KIRKLEES METROPOLITAN COUNCIL INVESTMENT & REGENERATION SERVICE

DELEGATED DECISION TO DETERMINE PLANNING APPLICATIONS

Reference No:	2022/62/91604/W
Site Address:	66, Blacker Road, Birkby, Huddersfield, HD1 5HS
Description:	Alterations to existing dwelling to form 3 flats with rear dormer and erection of bike shed (within a Conservation Area)
Recommending Officer:	Katie Chew

DECISION - Refusal

PROPOSED REAR ELEVATION

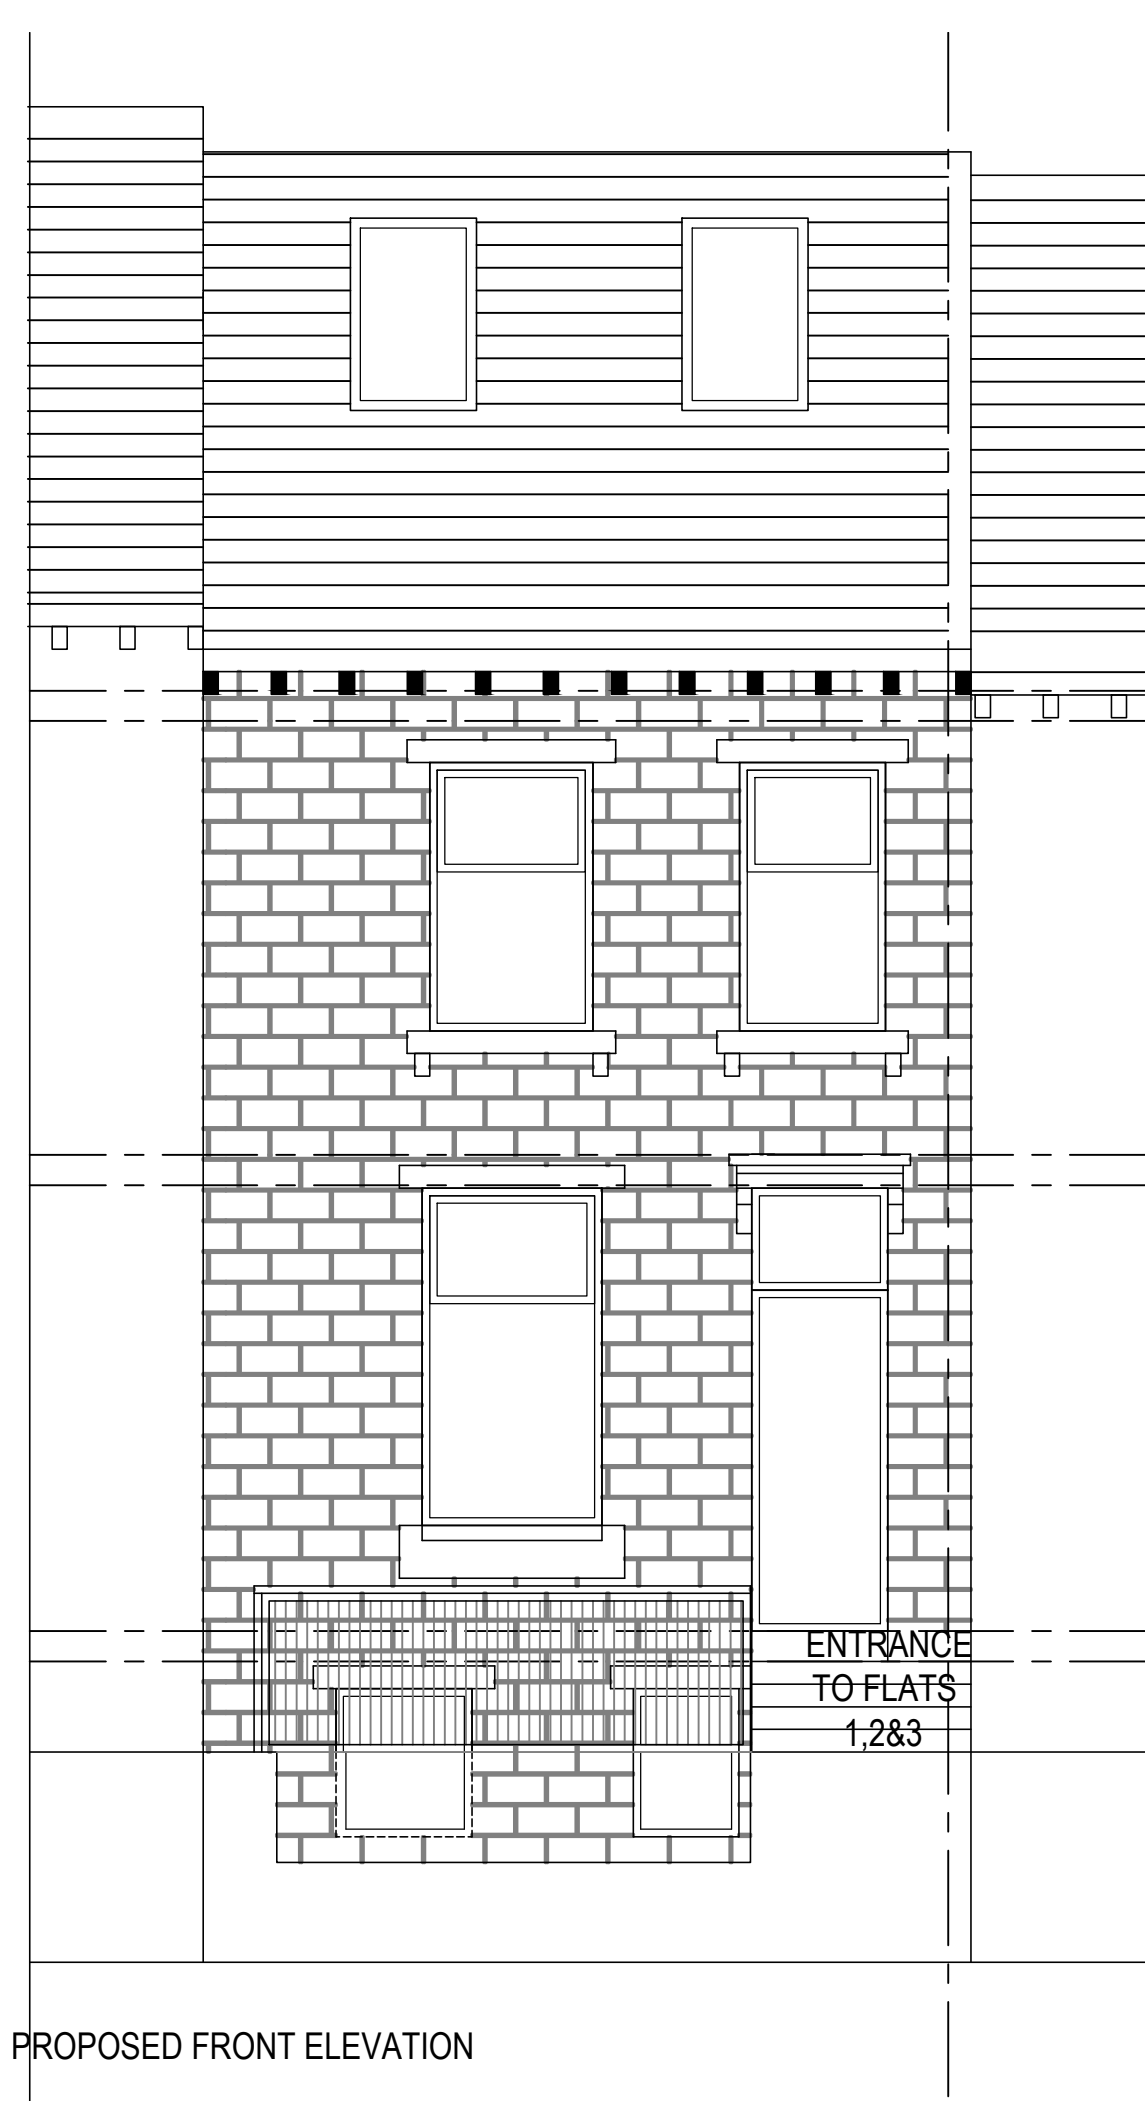
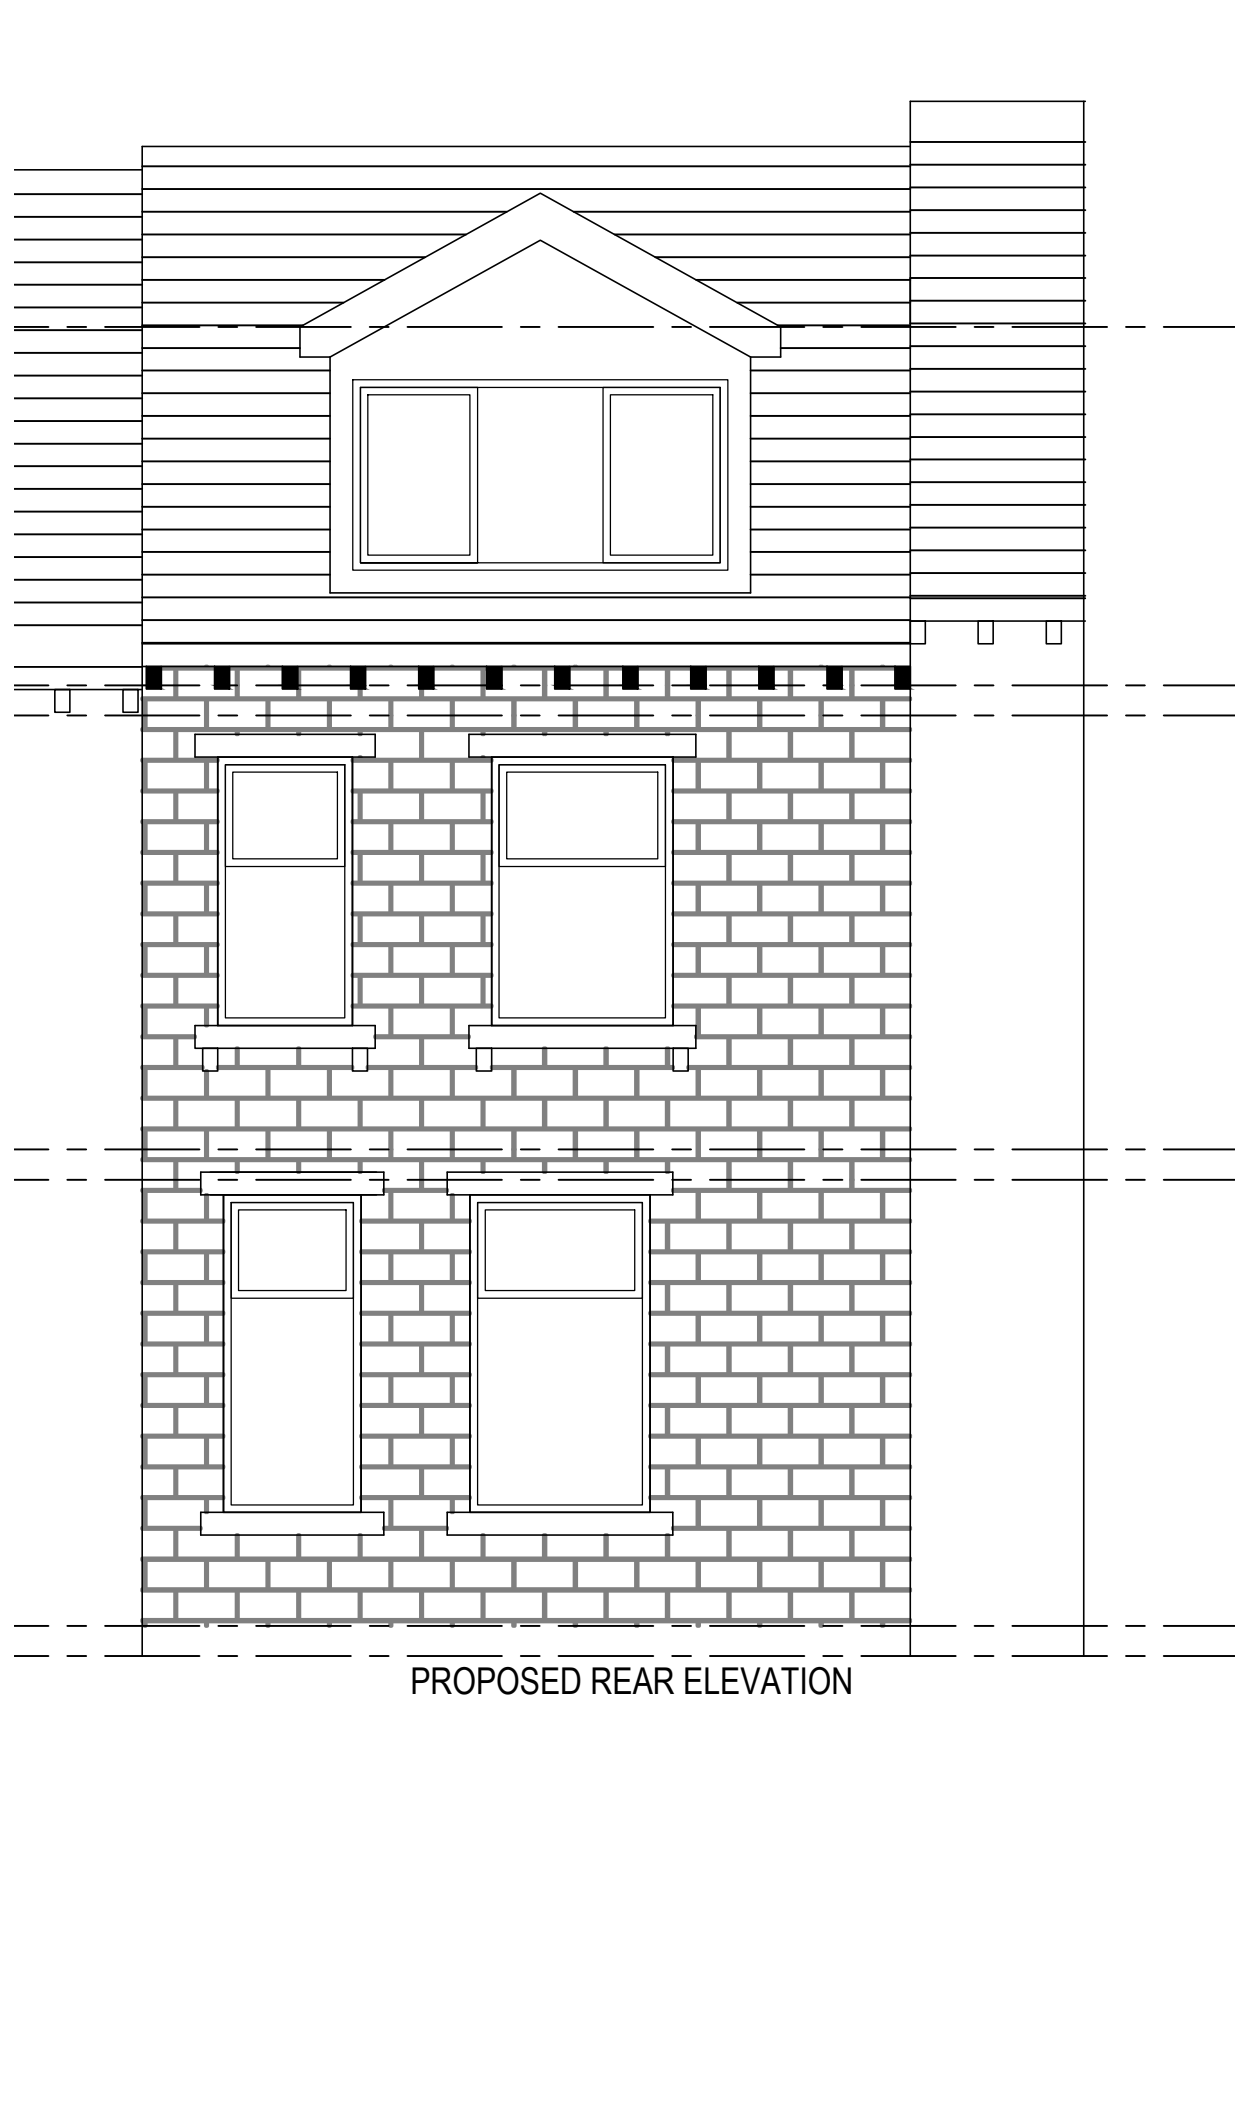
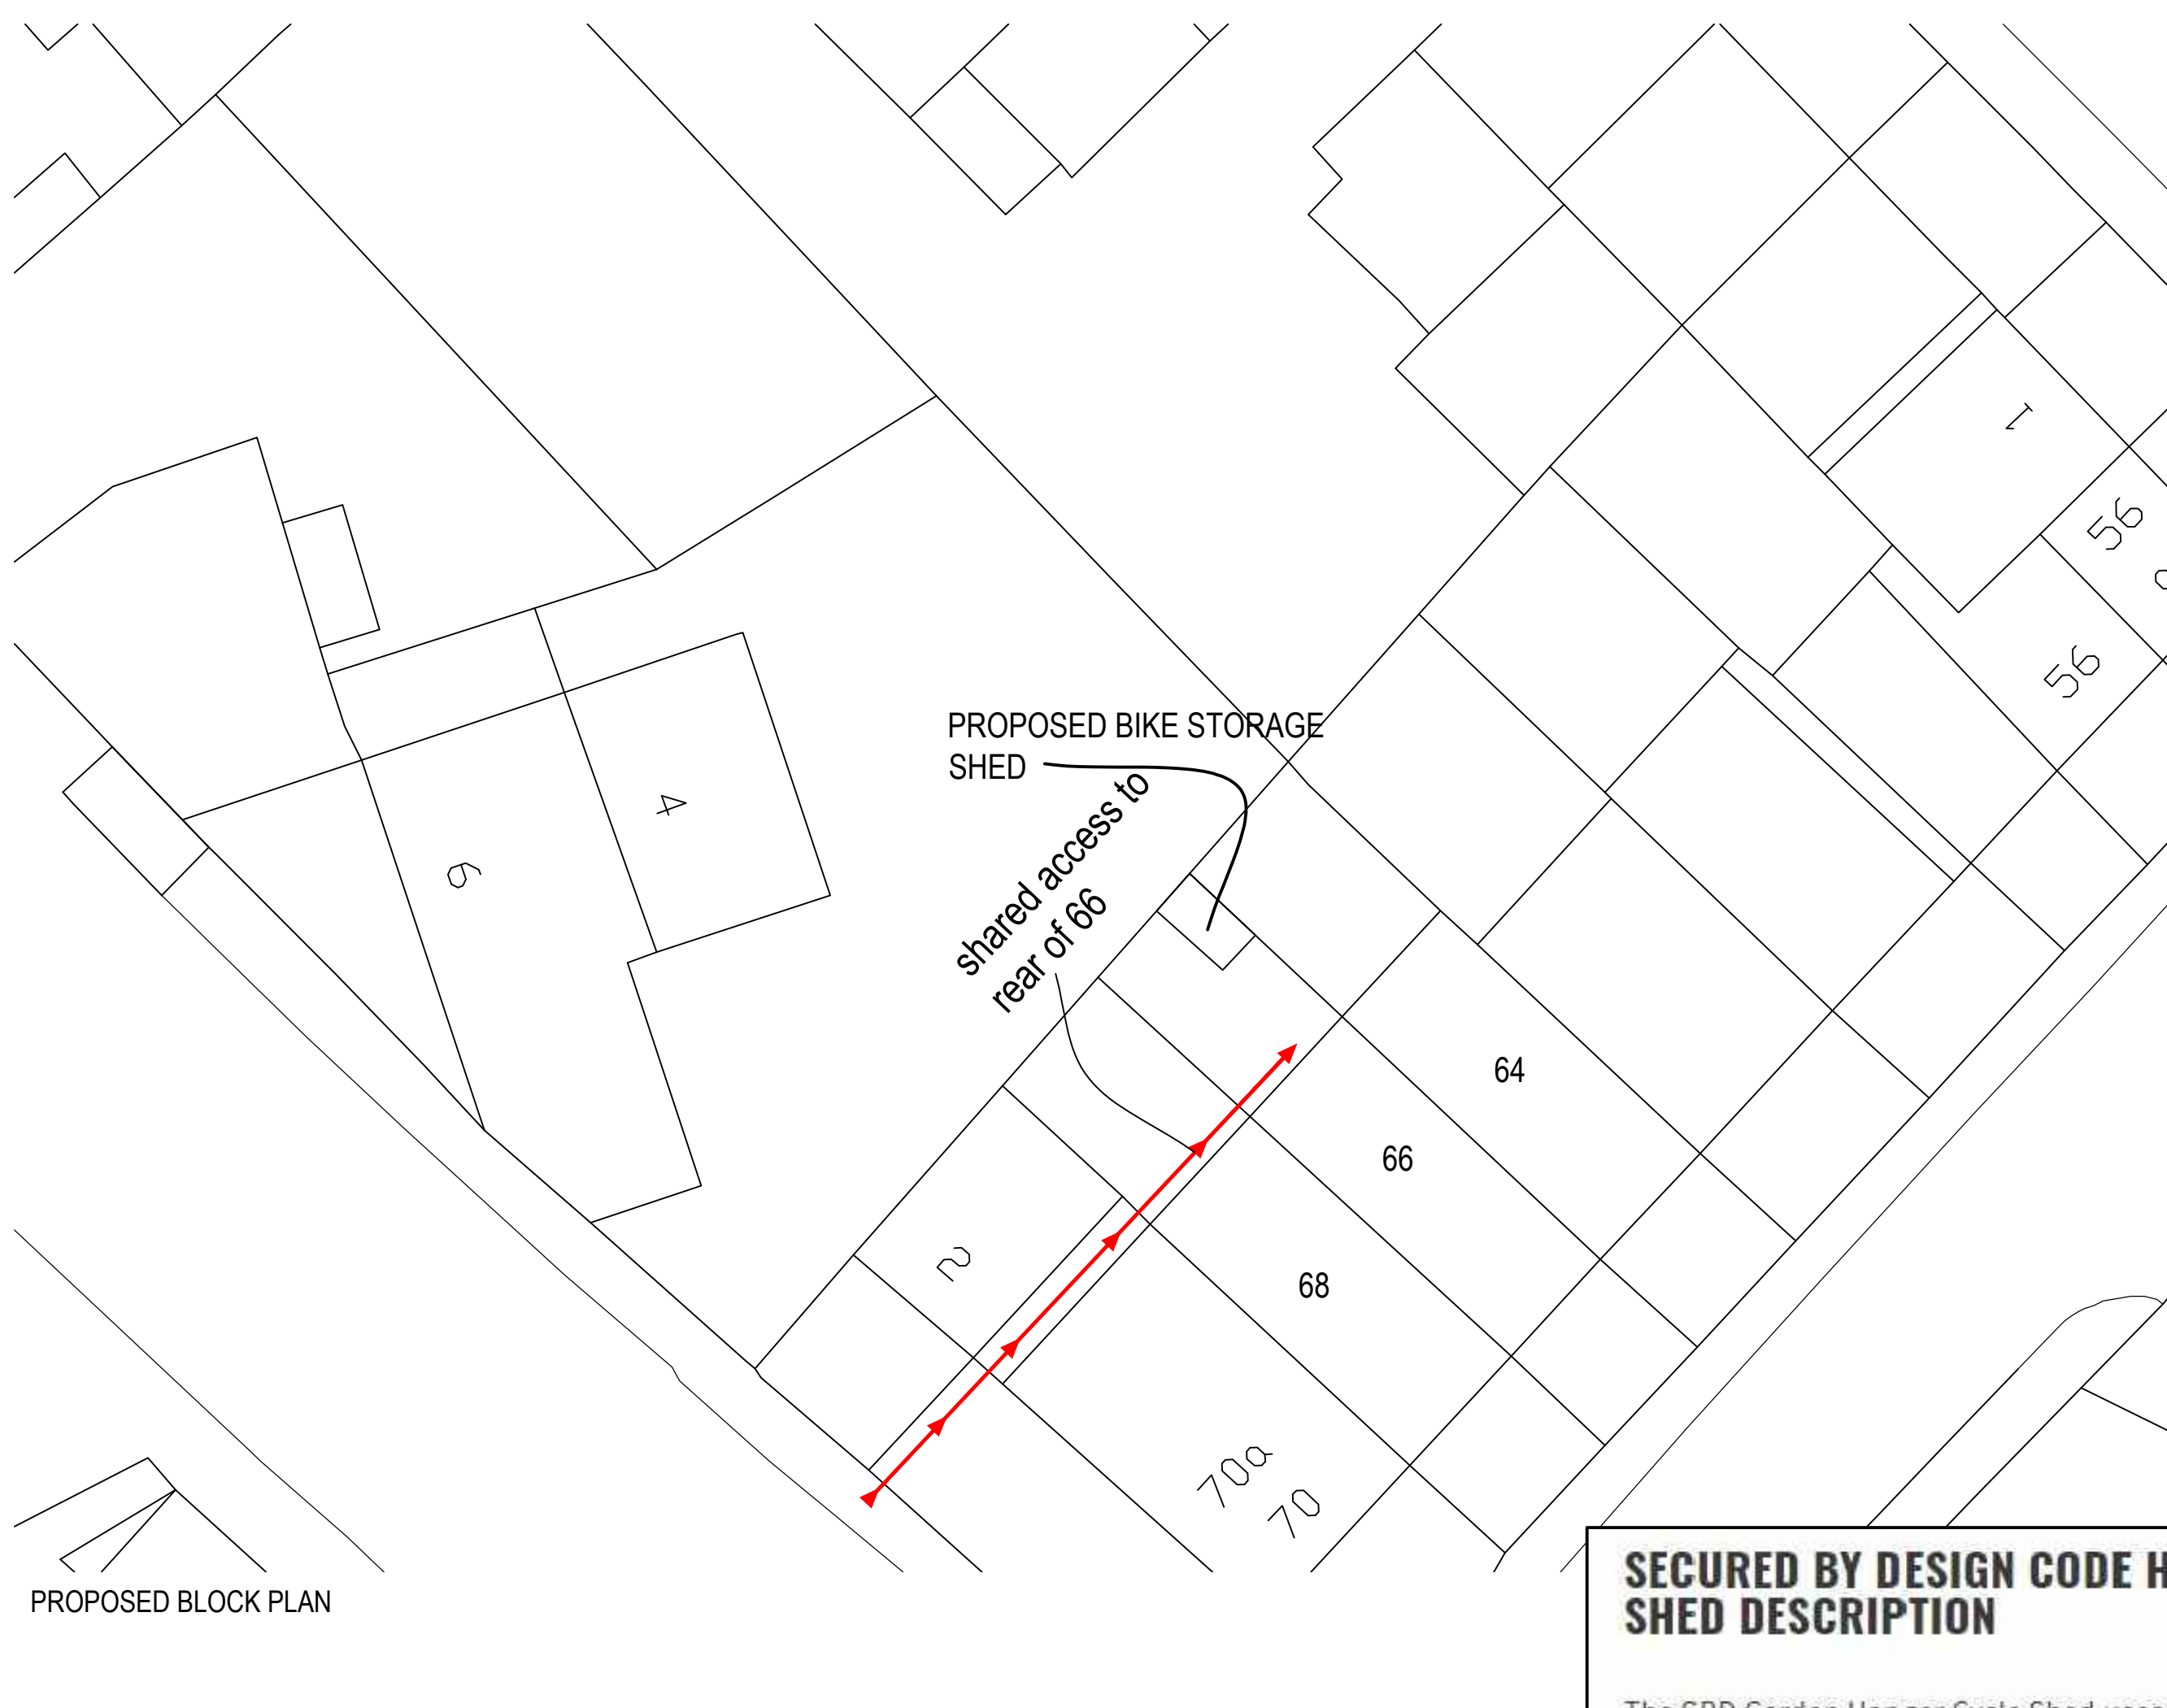
To the rear of the dwelling a new dormer window is proposed. The dormer is to measure approximately 2.7m in width, and 2.6m in height. No side elevation drawings have been provided and therefore the depth of the proposed dormer window is unknown. Given previous discussions with the Council's Conservation & Design team on the erection of dormer windows at this property under previously refused application 2021/91035 it is considered that inserting a dormer window on the rear roof pitch will lead to less than substantial harm to the significance of the conservation area (the designated heritage asset) by breaking up the simple line of the pitched roofs along this terrace. The harm will be particularly pronounced to the rear pitch as it is visible from Wheathouse Road and is seen in context with the two listed buildings. The proposed bulky and disproportionate dormer is not considered to preserve or enhance the significance of the conservation area or maintain the distinctive character of the repetition of the terraces and clean roof lines, which are an important part of the character of this conservation area.

2. The proposed rear dormer window, by reason of its siting, massing, form and design, would introduce an unsympathetic, incongruous, disproportionate and dominant addition to the host property No. 66 Blacker Road. The proposed dormer would not maintain the distinctive character of the repetition of the terraces and clean roof lines, which are an important part of the character of Birkby Conservation Area. The development would therefore cause detrimental harm to the visual amenities and overall character of the area. The proposal would also cause less than substantial harm to the significance of the Birkby Conservation Area and the nearby Grade II listed buildings of No. 4 Wheathouse Road and No.6 Wheathouse Road which no convincing justification or public benefits have been provided. The proposal would therefore be contrary to Policies LP1, LP24 and LP35 of the Kirklees Local Plan, Chapters 12 and 16 of the National Planning Policy Framework, Sections 66 and 72 of the Planning (Listed Building and Conservation Areas) Act and Principles 2 and 15 of the Council's adopted Housebuilders Design Guide SPD.

PROPOSED GROUND FLOOR PLAN
(FLAT 1)

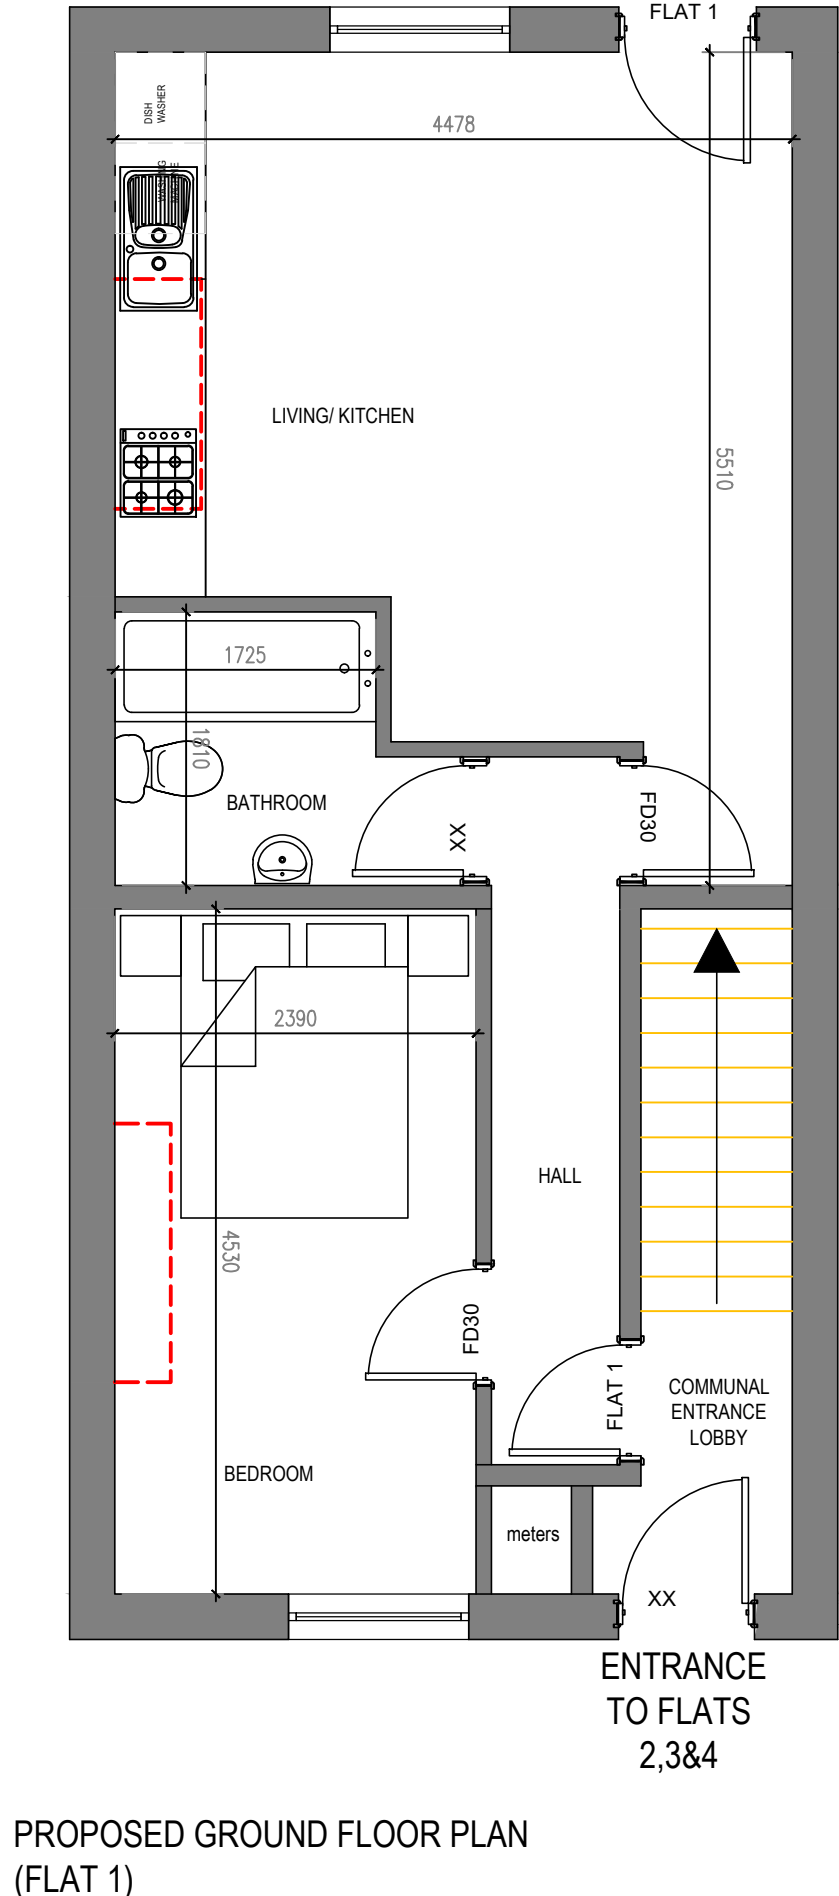
To the front of the dwelling a new lightwell is to be erected. Whilst no details have been provided in relation to the basement of the dwelling as outlined within the previously refused application ref. 2021/91035, officers would like to reiterate that this basement would not provide suitable living accommodation for an additional flat, this is due to lack of outlook, natural light and concerns in respect to noise generated from Blacker Road. However, in terms of visual amenity, given that the lightwell will be small in scale and size it is considered acceptable in this location.

With regards to Flat 1 the double bedroom has an approximate floor area of 10.68sqm and a width of 2.39m. Thus, supporting the view that this bedroom should be occupied by one single person. The bedroom at Flat 2 has an approximate floor area of 11.9sqm and a width (at its smallest) of 3.3m. The bedroom at Flat 3 has an approximate floor area (not taking into account floorspace which has a head height of less than 1.5m) of 12sqm and a width of 4.6m.
